DEVELOPMENT HEARING OFFICER

Planning - Case Comments

Project Number: PR-2019-2284 AKA 2018-001774

Project Name: Andretti's Racing

<b>ANDRETTI'S RACING ALBUQUERQUE, NM</b>	DRAWN BY JL
	<b>SITE PLAN EPC-MAJOR AMENDMENT</b>	DATE 9-22-22
		DRAWING
		SHEET # <b>SP-1</b>
		JOB # 2022011

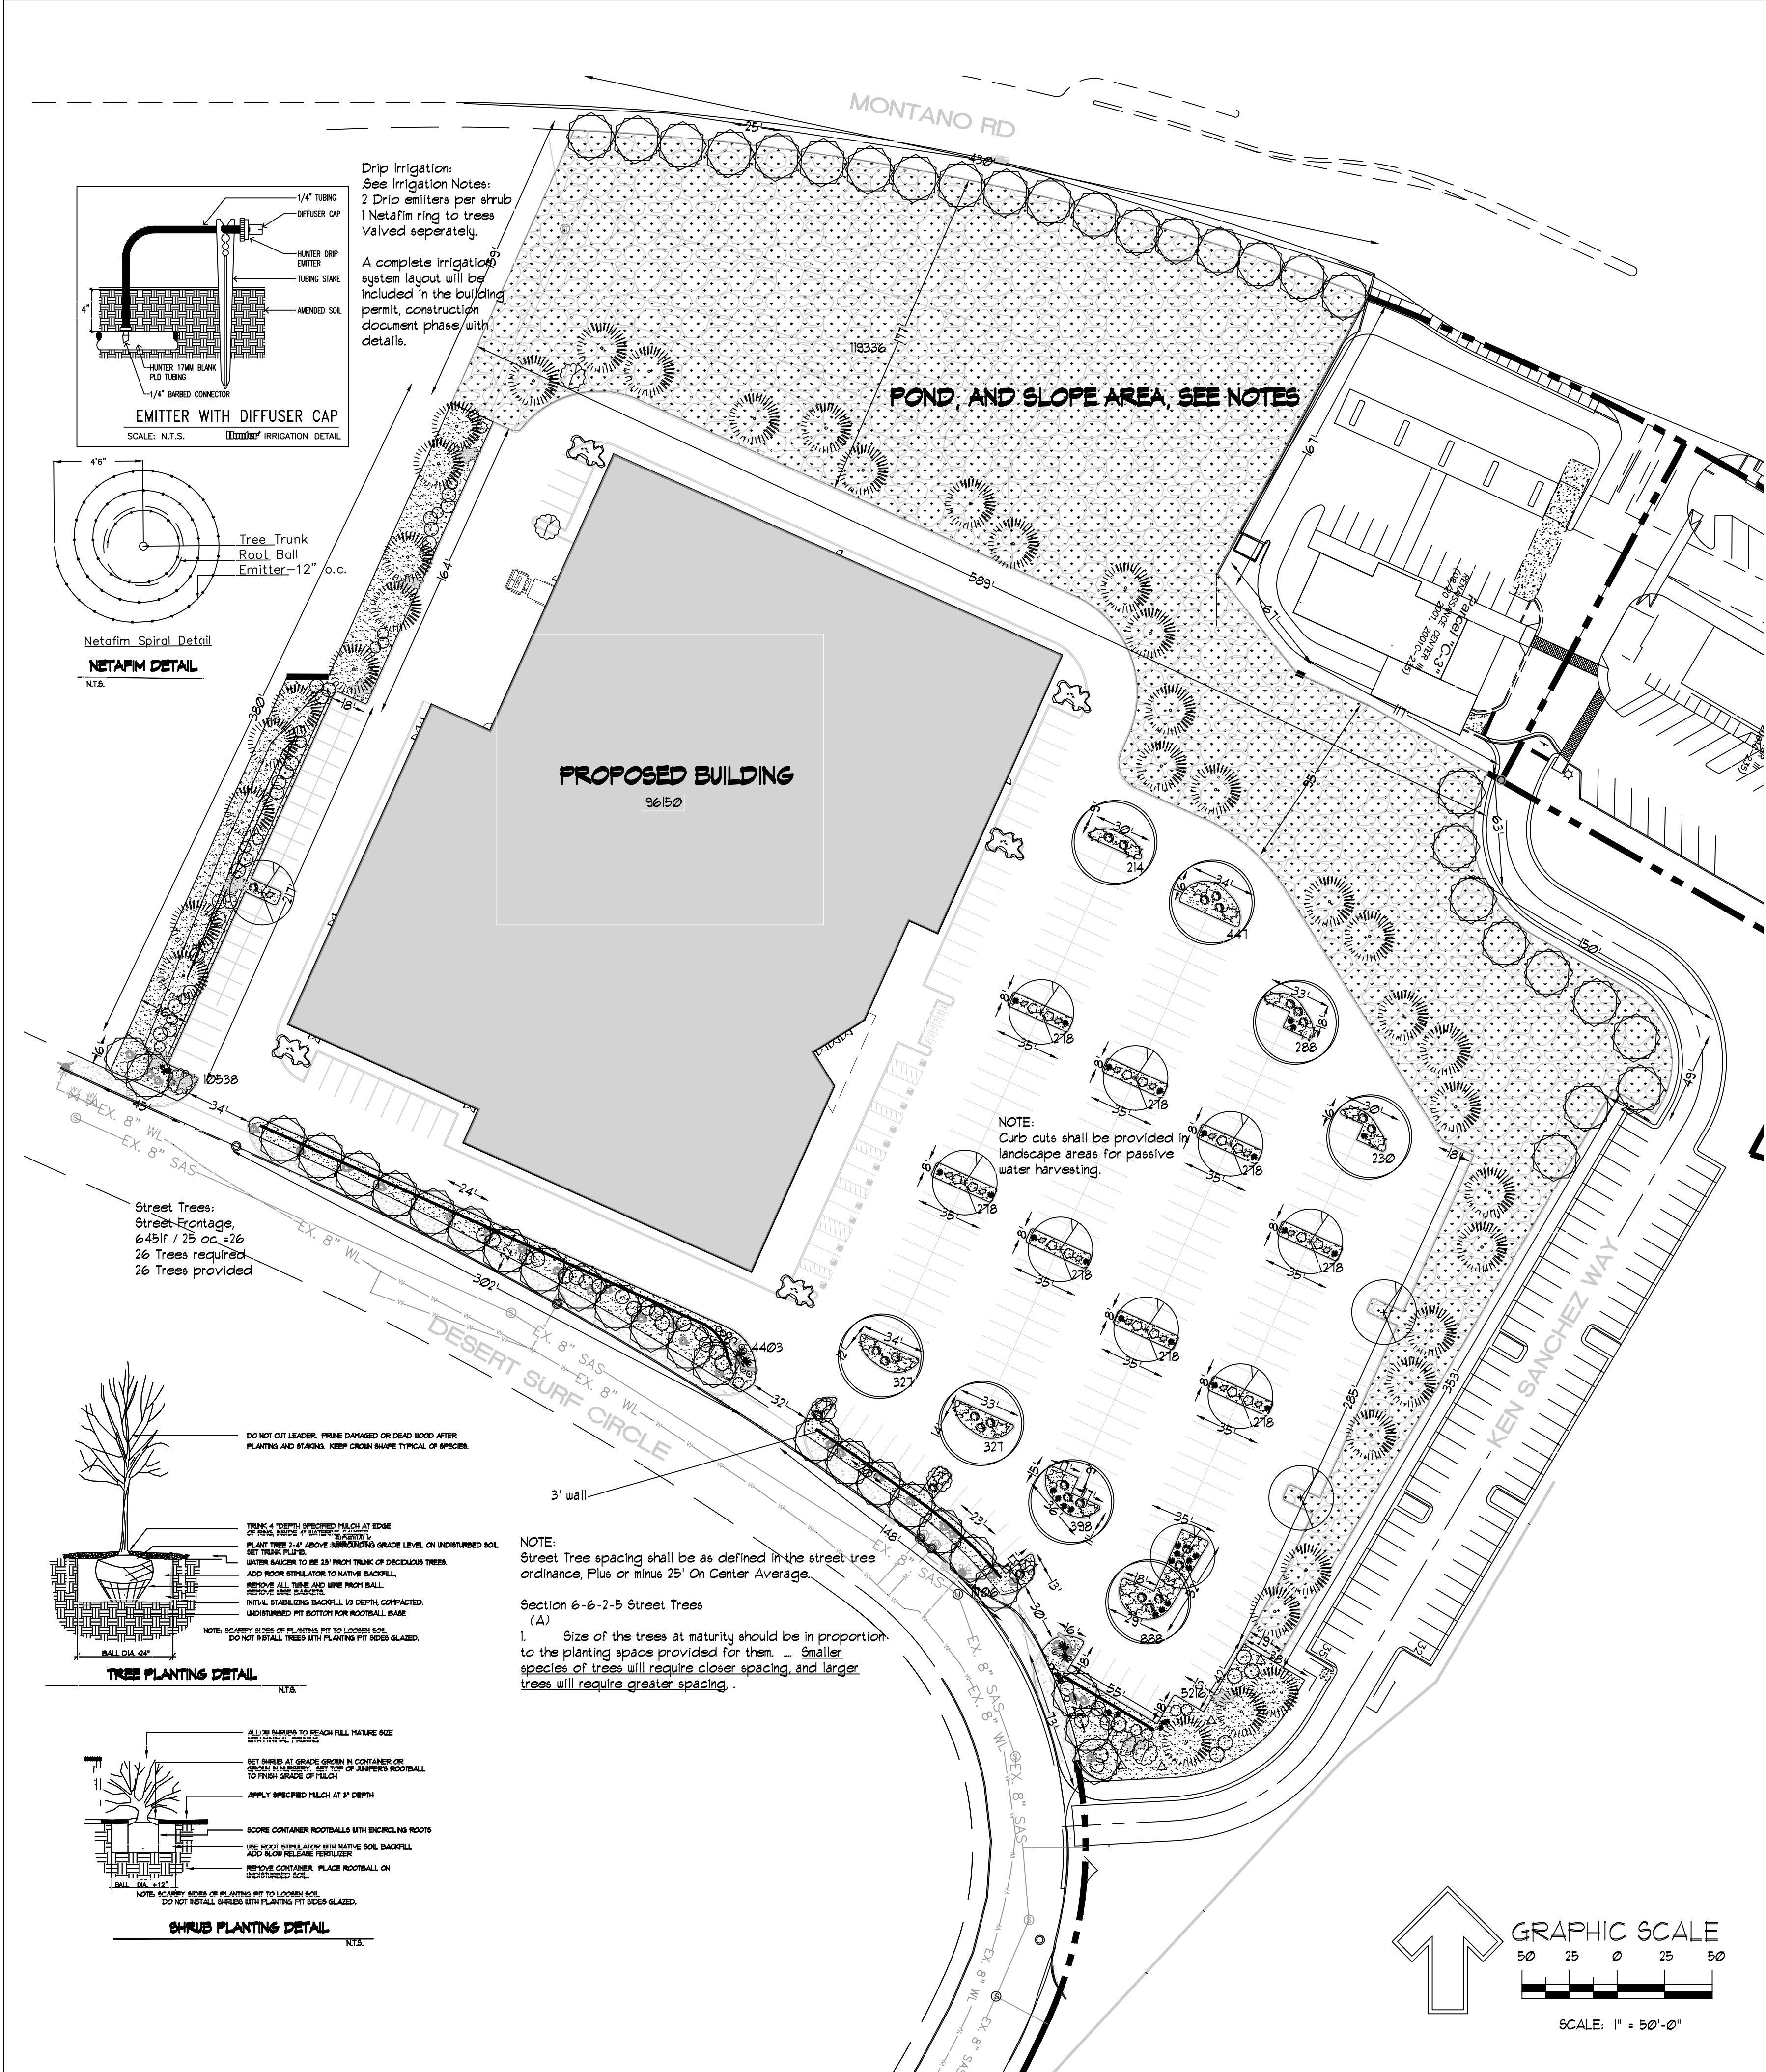
1. Transportation has an approved Conceptual TCL dated 11/22/2022 and an approved TIS dated 10/24/2022.
2. The new 5' sidewalk along Desert Surf should be listed on the infrastructure list.

No Comments for requested plat. Please address trees in streetscape with Site Plan.

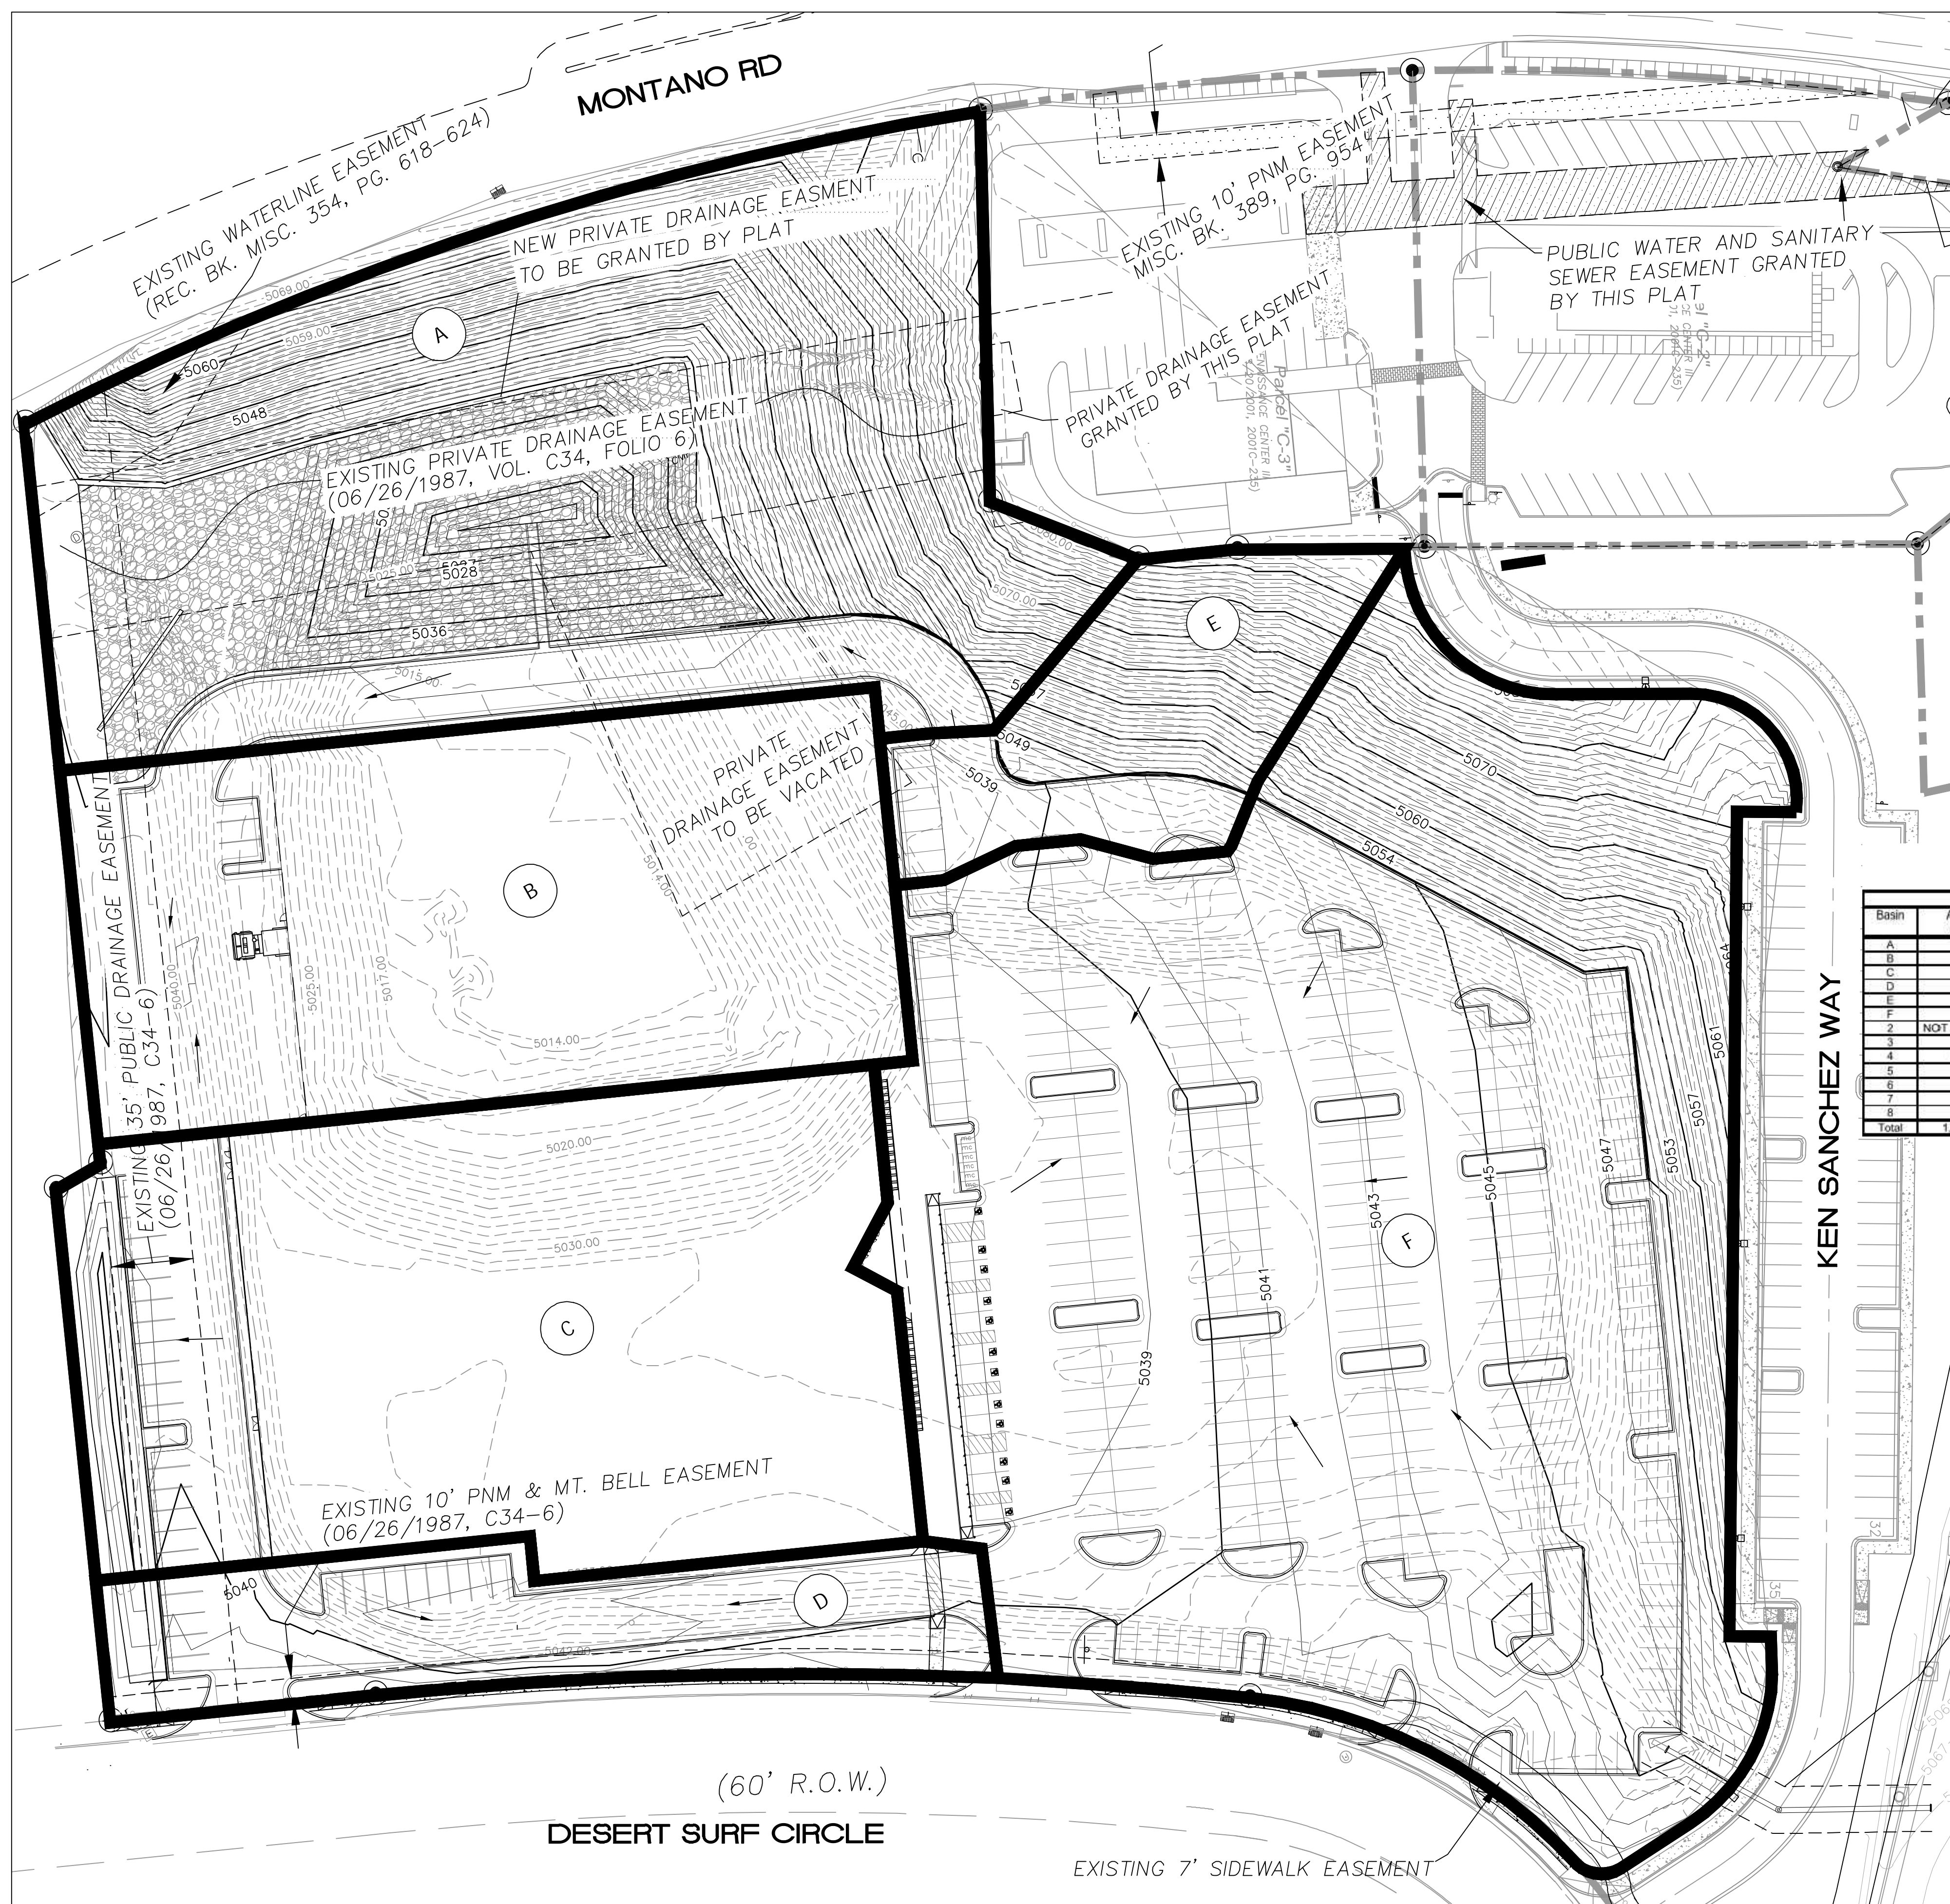
- **The notes on the Landscaping Plan regarding 'Drainage Basin Treatments' need to be updated** to reflect the following Standard Specifications for Drainage Ponds.
